Campbell's Cove

Deletion of Stage 4 Ports Authority Works

SYDNEY HARBOUR PROMENADE DESIGN RESPONSE TO SUBMISSIONS

NOVEMBER 2017

01 HICKSON ROAD ENTRY
SCALE 1:50

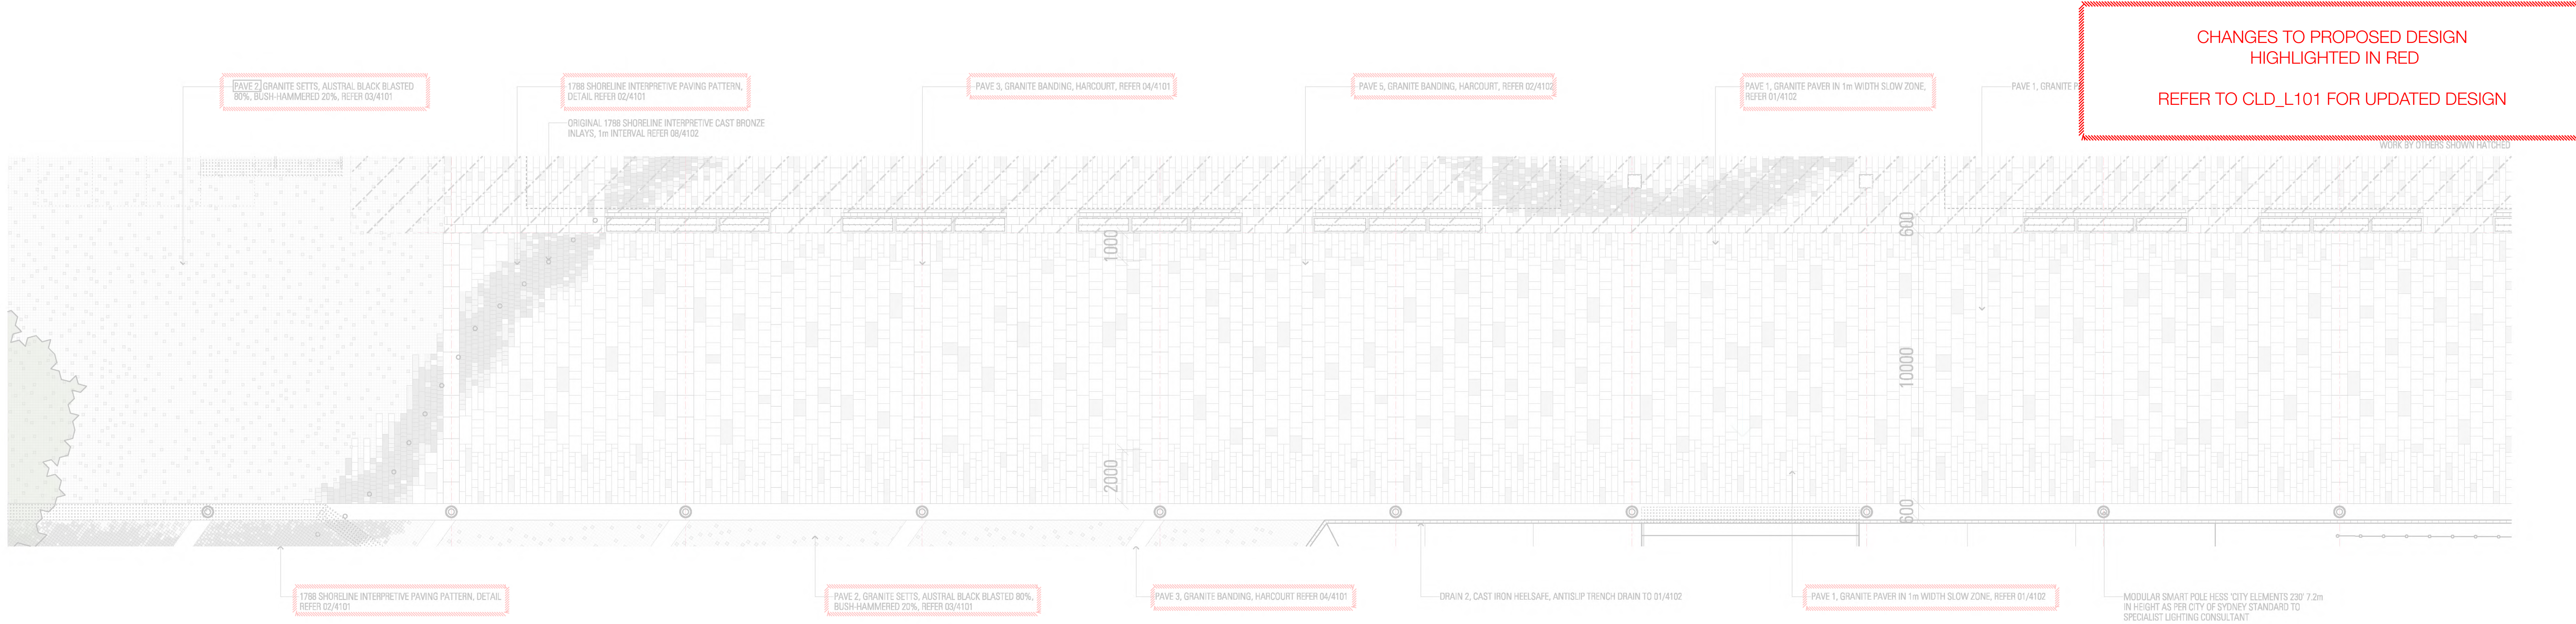
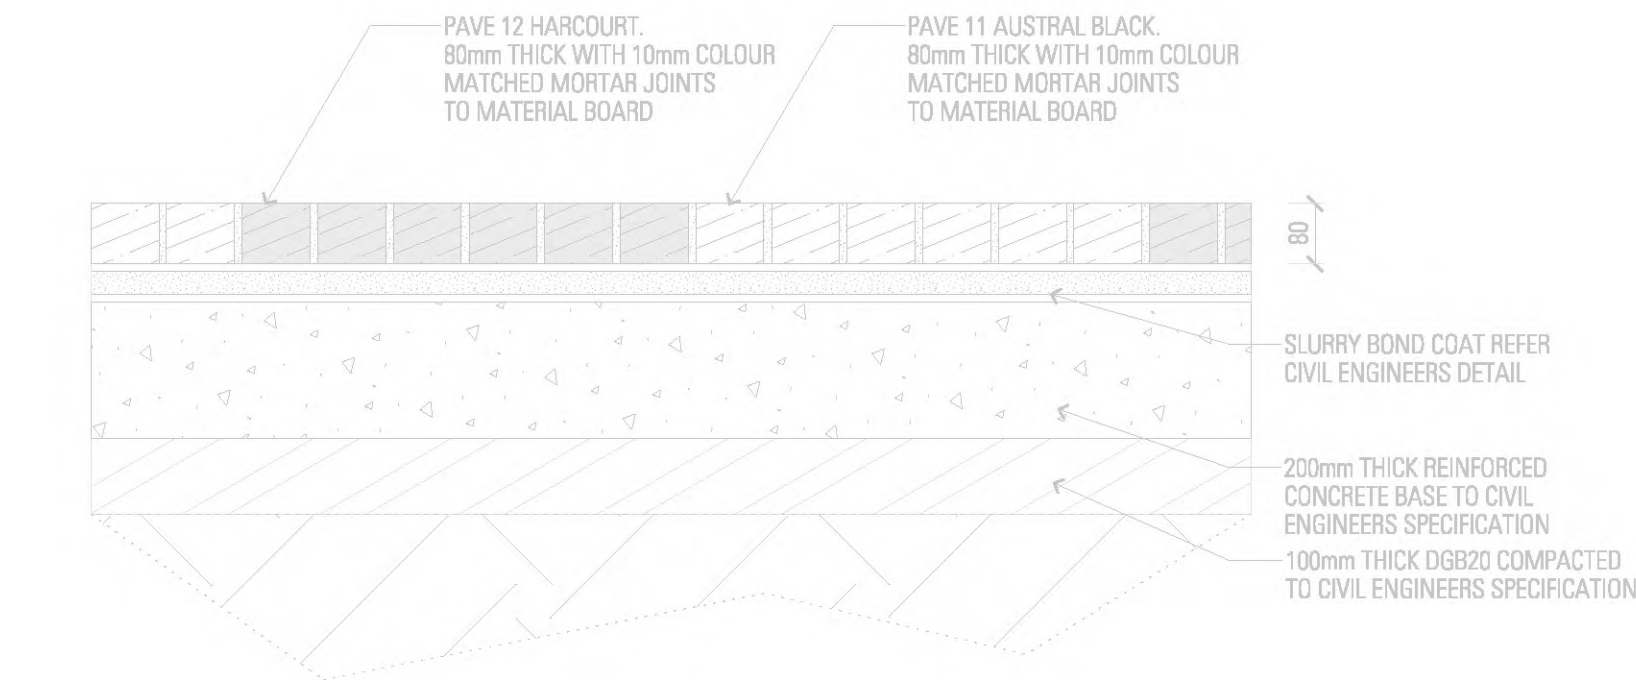
"The City would prefer vehicular access to be redesigned to give priority to pedestrians and cyclists. This can be achieved by continuing the type of footpath material and grade (i.e. continuous footpath pavement)" City of Sydney submission.

This option raises the junction between Hickson Road and the Overseas passenger terminal. The raising of the junction eliminates existing speed humps as the entire threshold is raised. In addition, pram ramps have been eliminated and thus allows pedestrians and cyclists to utilize the full width of footpath to cross the threshold.

The use of small paving units helps delineate the crossing threshold whilst providing a visual, textural and (roughness) contrast to signify a change in condition and slow pedestrian and cyclist crossing the vehicle crossing.

01 PAVE 1 GRANITE PAVING - TYPICAL LAYOUT
SCALE 1:20

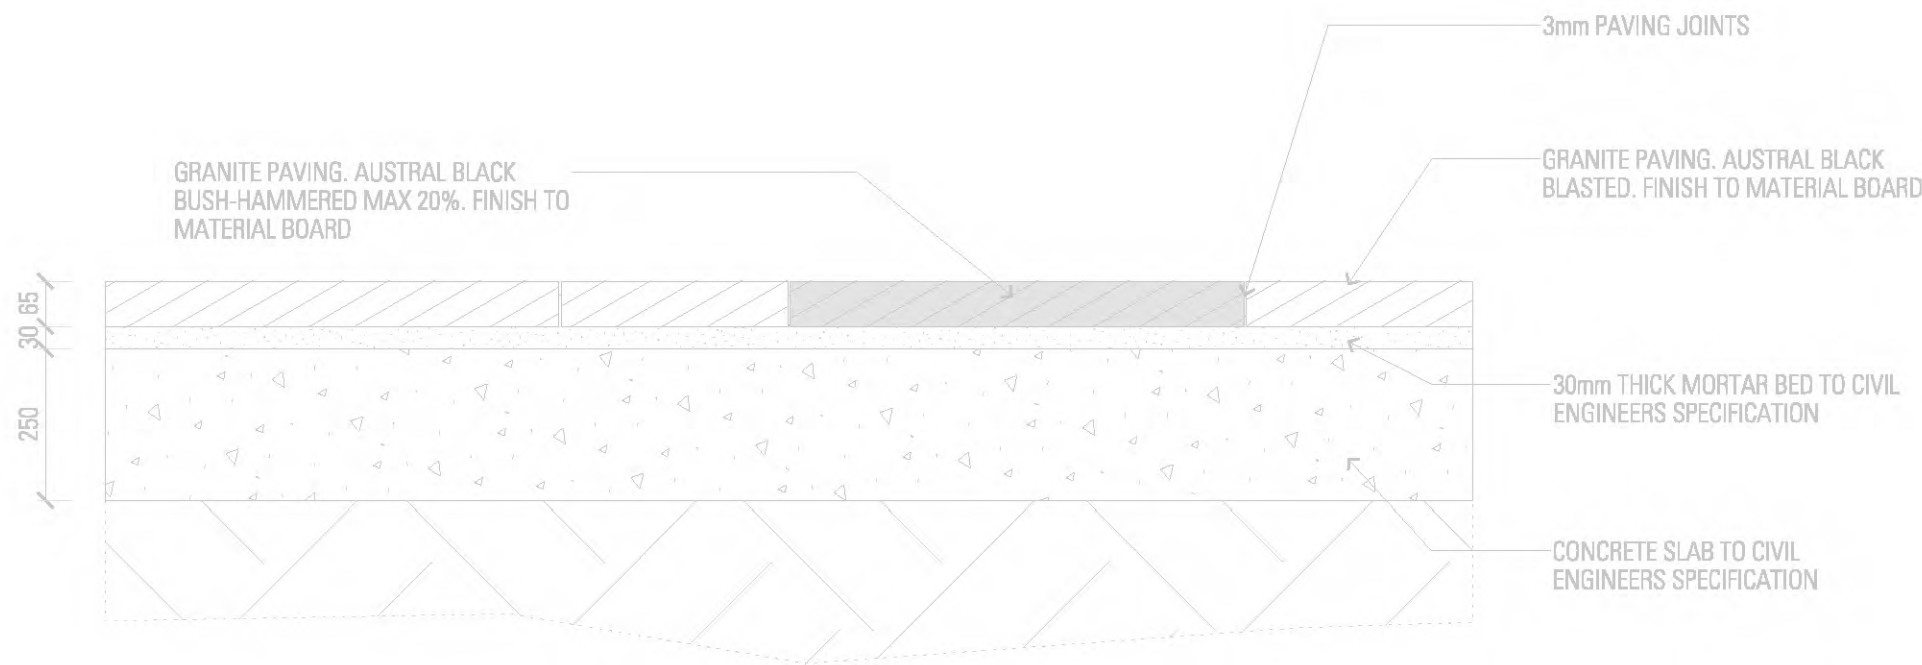
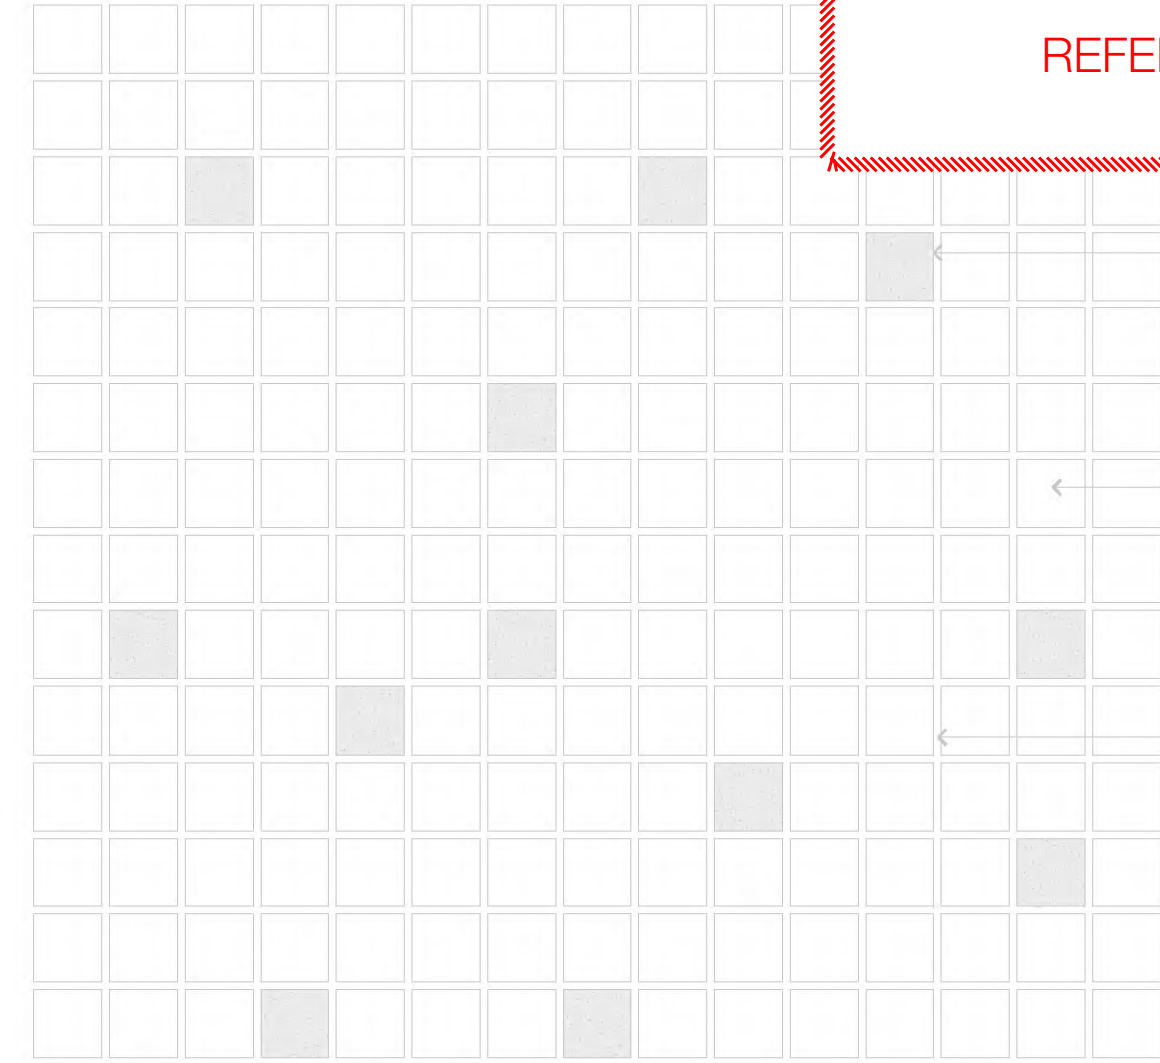
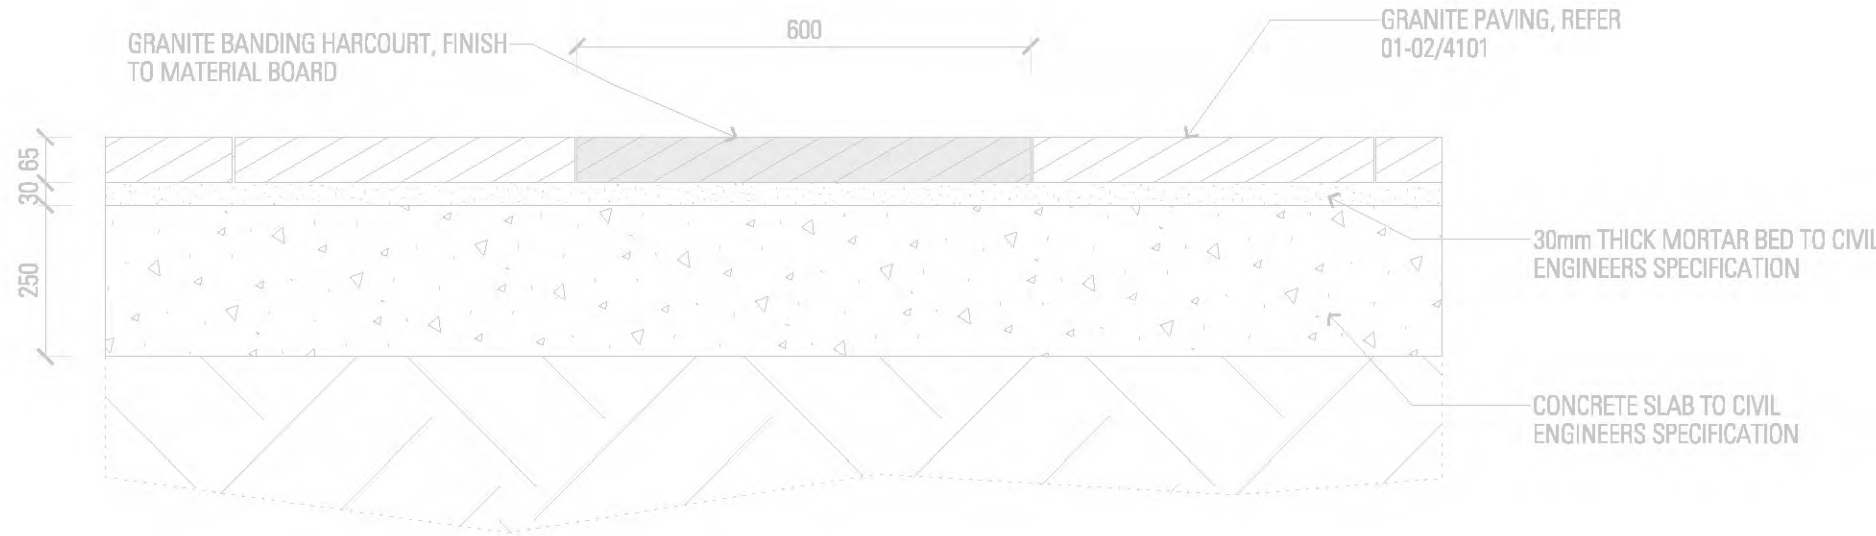
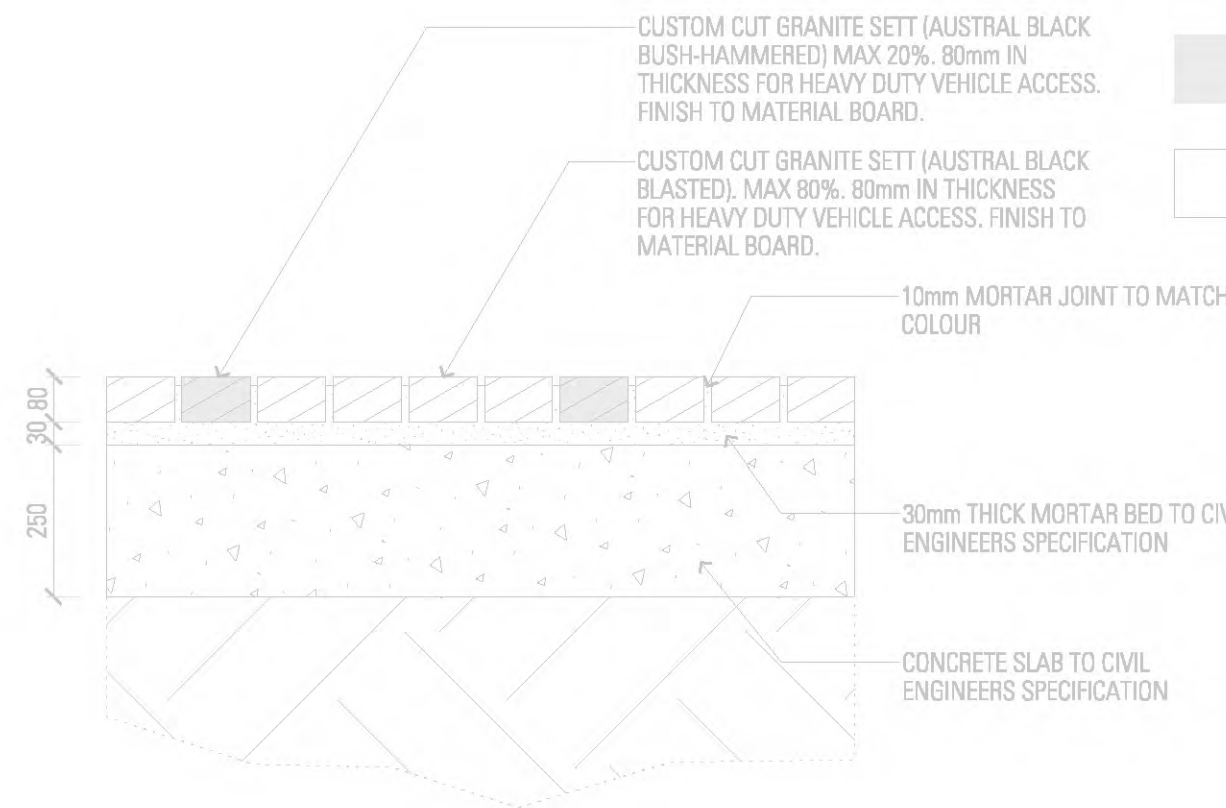
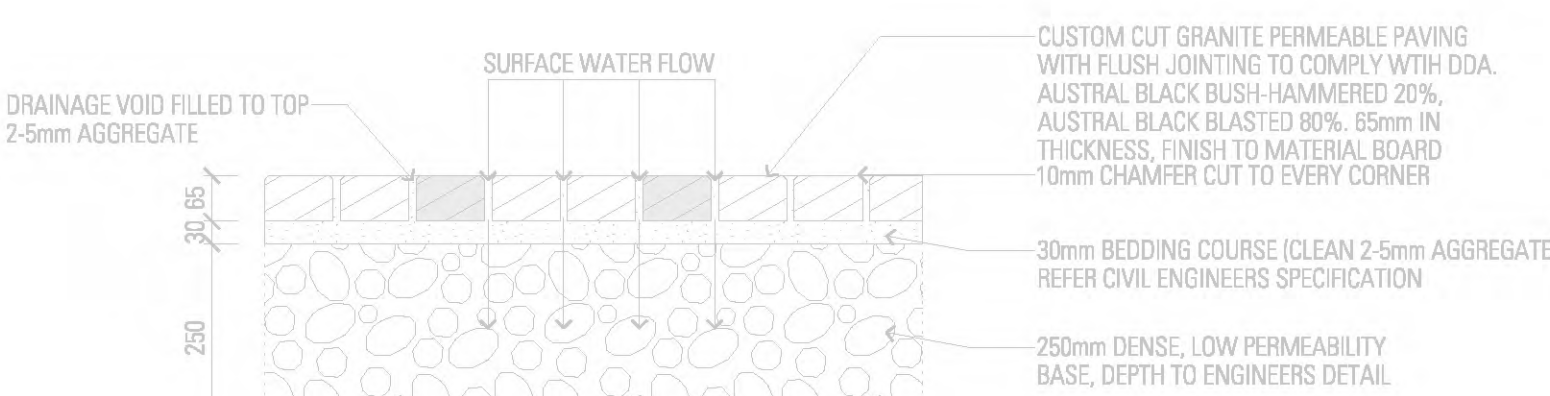
"The City recommends that consideration be given to simplifying the design to better unify the space. Consideration should also be given to replacing the concrete boardwalk with timber to unify the edge of the cove".

Taking these comments into consideration, Context's design response provides a simplified paving pattern in line with the Circular Quay Public Domain Manual, in a dark colour with 30% light coloured inflections in 'Austral Verde' and 'Juparana'. The pavement design utilizes the austral black granite paver arranged in the standard City of Sydney arrangement as the body paver unit. A variety of finish types in conjunction with the 30% contrast will give a level of diversity and complexity to the pavement design and help to unify the overall pavement treatment of the site.

- Simplify paving pattern and comply with the Circular Quay Public Domain Manual
- Use Granite with grey tones near shoreline with inflections of sandstone shades towards Campbell's Stores
- Bronze inlays are currently included in the shoreline pattern.
- If the Shoreline paving detail is undertaken as part of the Campbell's stores upgrade, then it should be completed as part of the Campbell's Cove upgrade
